**Elizabeth Drive Biodiversity Assessment
Response to Environment, Energy and Science comments on ammended EIS**

This letter presents GHD Pty Ltd (GHD) responses to Environment, Energy and Science (EES) comments on the Biodiversity Development Assessment Report (BDAR) dated August 2020 for the proposed industrial subdivision at 1111-1141 Elizabeth Drive, Cecil Park, NSW (Lot 2 DP 2954) (the proposal).

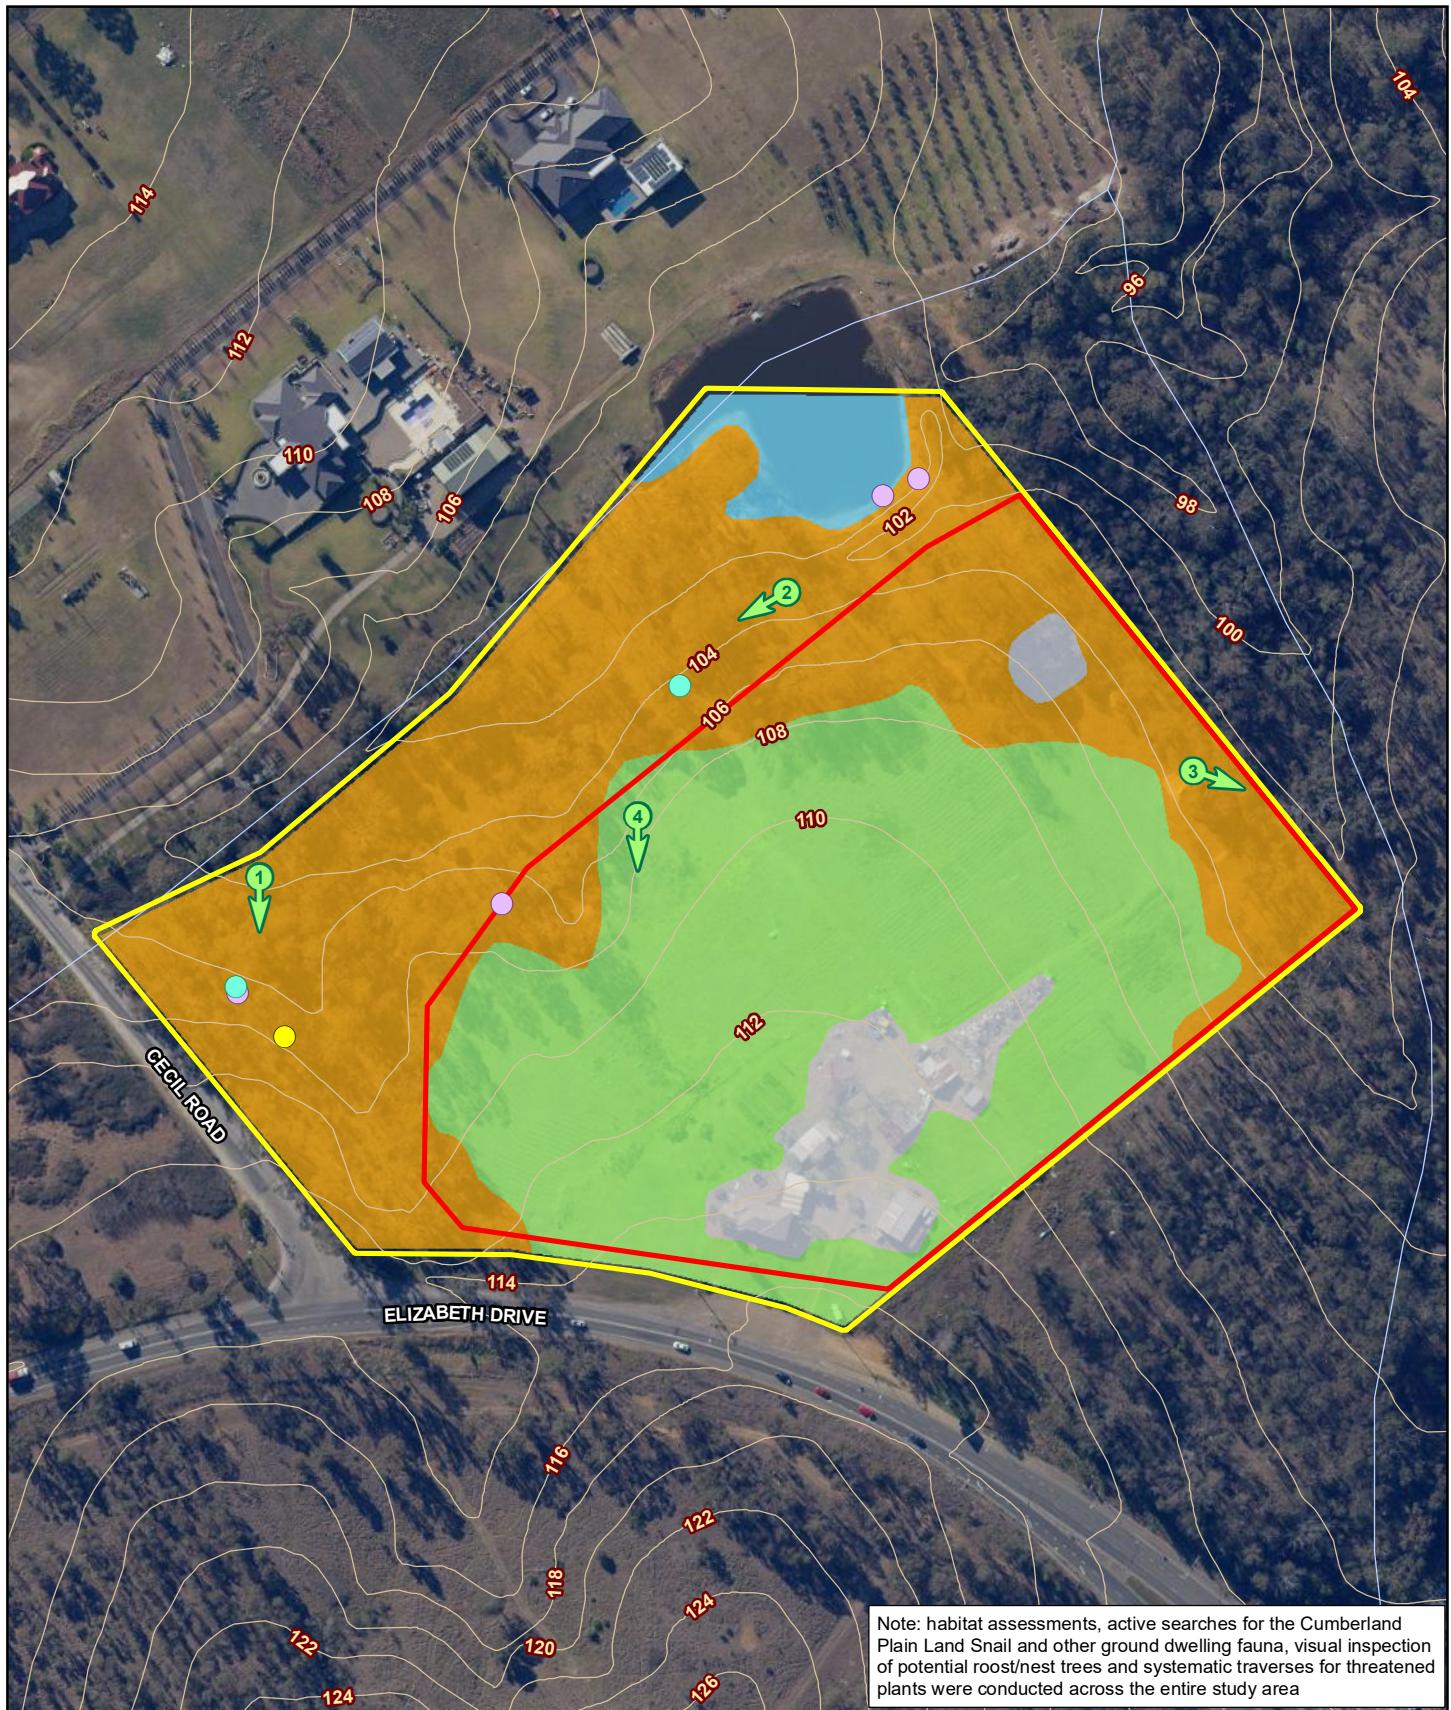
<p><i>Mapping native vegetation extent</i></p> <p>An area within the Cumberland Plain Woodland (CPW) has been mapped as "Buildings, infrastructure and dumped fill" (Figure 2-1) and has been identified as not requiring assessment (page 54) or offsets (Figure 6-1). However, recent aerial imagery (Nearmap dated Friday October 2 2020) shows no obvious differences between this area and the surrounding</p>	<p>It is recognised that recent satellite aerial photography appears to indicate continuous native vegetation cover across the northern portion of the subject site. It is noted that according to section 5.1.1.7 of the BAM, an assessor must identify any areas of native vegetation extent that are different to the satellite or ortho-rectified aerial image on the Site map and describe the changes in the extent of native vegetation.</p>	<p>Section 3.1.10 Section 3.2.1</p>

<p><i>Targeted surveys</i></p> <p>Figure 2-1 contains the following “Note: habitat assessments, active searches for the Cumberland Plain Land Snail and other ground dwelling fauna, visual inspection of potential roost/nest trees and systematic traverses for threatened plants were conducted across the entire study area”. However, no GPS tracks are mapped for this and no field data sheets are included in an appendix. As such, sections 6.5.1.3 and 6.5.1.5 of the BAM need to be applied.</p>	<p>GPS track logs were not captured because the study area is just 7.37 ha in area and contains ~3 ha of native vegetation and habitat, on a single lot that is flat and with open vegetation. The entire study area could be readily traversed and visually inspected for candidate threatened species within the dedicated survey effort of at least four hours of searching by two ecologists walking parallel transects spaced 10 m apart in March and November 2018. It was not considered</p>	<p>Scanned copies of field data sheets provided as attachments via BOAMS as per the request for shape files.</p> <p>Section 2.2.1</p> <p>Section 2.2.5</p>

Issue raised by EES	GHD response and scope of works	Where addressed
<p>vegetation and section 5.1.1.3 of the BAM states “The native vegetation extent on the subject land includes all areas of native vegetation including native ground cover and the canopy area of trees.” As such, justification for this mapping needs to be provided in accordance with section 5.1.1.7 of the BAM, and section 10.4.1.1 may also need to be revisited.</p>	<p>The area of ‘Buildings, infrastructure, and dumped fill’ surrounded by native woodland in the northern portion of the site appears similar to native vegetation on the base aerial image shown on the site map because of shadow from trees farther to the north-west. Note the long shadows visible throughout the image. These areas were inspected by field ecologists and do not contain any native groundcover vegetation or over-hanging canopy vegetation. Further, the soil profile has been compacted and covered with fill and refuse and does not have any capacity for regeneration of native vegetation.</p> <p>The BDAR has been updated with additional justification for the mapping of non-native vegetation in accordance with section 5.1.1.7 of the BAM, including photos of the area highlighted in the EES submission.</p>

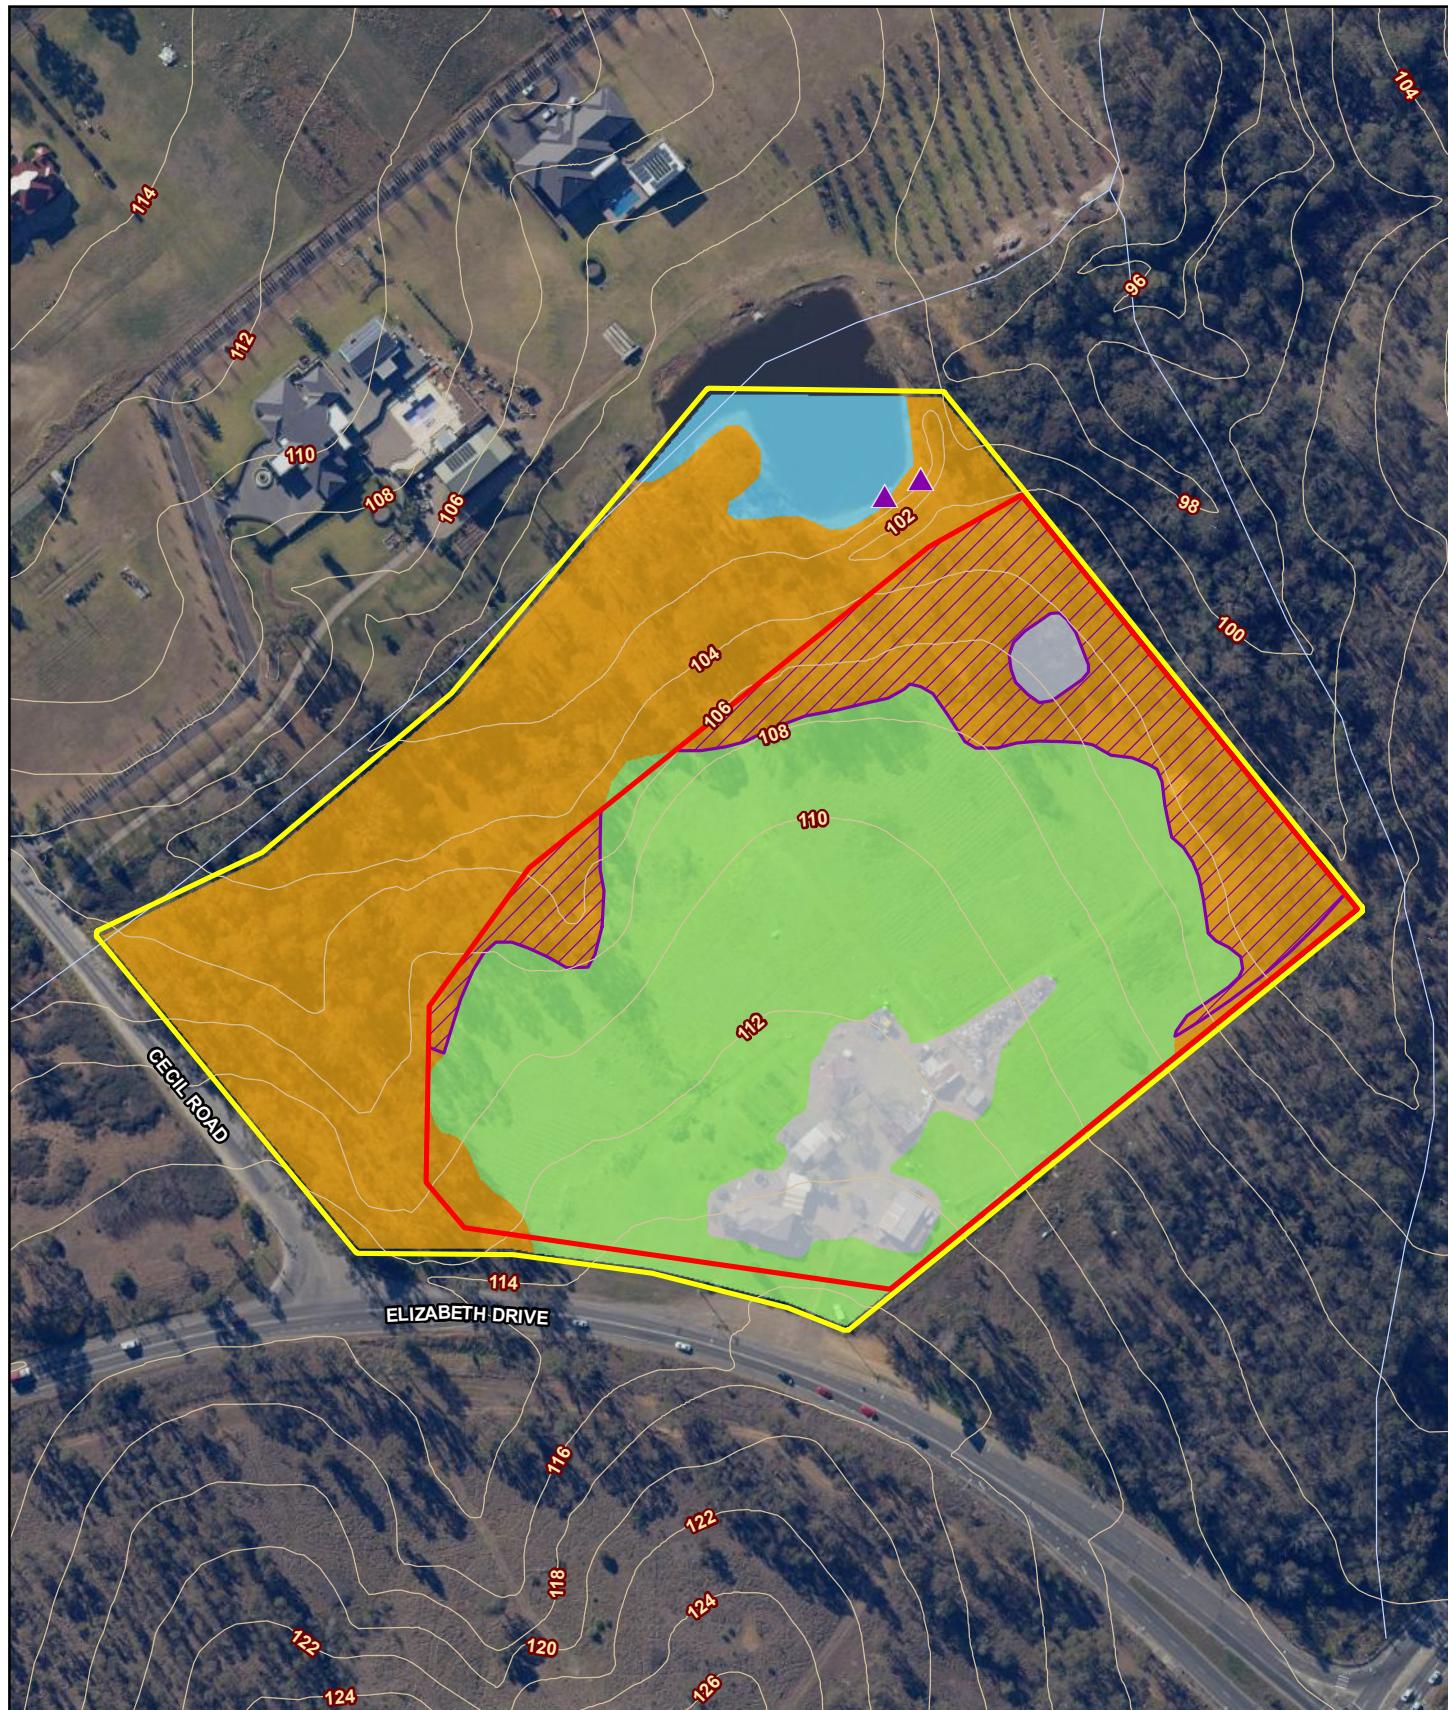
<p><i>Species polygon for Southern Myotis</i></p> <p>The polygon for Southern Myotis is incorrect. This is because the dam located near the junction of Cecil Road and Elizabeth Drive (on Lots 1 and 2 DP236527) is within 200m of the subject land but was not used to determine the species polygon; only the water body in the north west of the study area was (see page 56 of the BDAR). Bionet states “Use aerial imagery to map waterbodies with pools/stretches 3m or wider on or within 200m of the subject land. Species polygon boundaries should align with PCTs on the subject land to which the species is associated that are within 200m of waterbodies mapped”. As such, the species polygon for Southern Myotis needs</p>	GHD have updated the description and mapping of the species polygon for Southern Myotis to reflect the presence of the additional waterbody within 200 metres of the subject site. The credit calculations and the BDAR have been updated accordingly.	<p>Figure 6-2</p> <p>Section 6.6</p> <p>Section 9</p> <p>Appendix E</p>
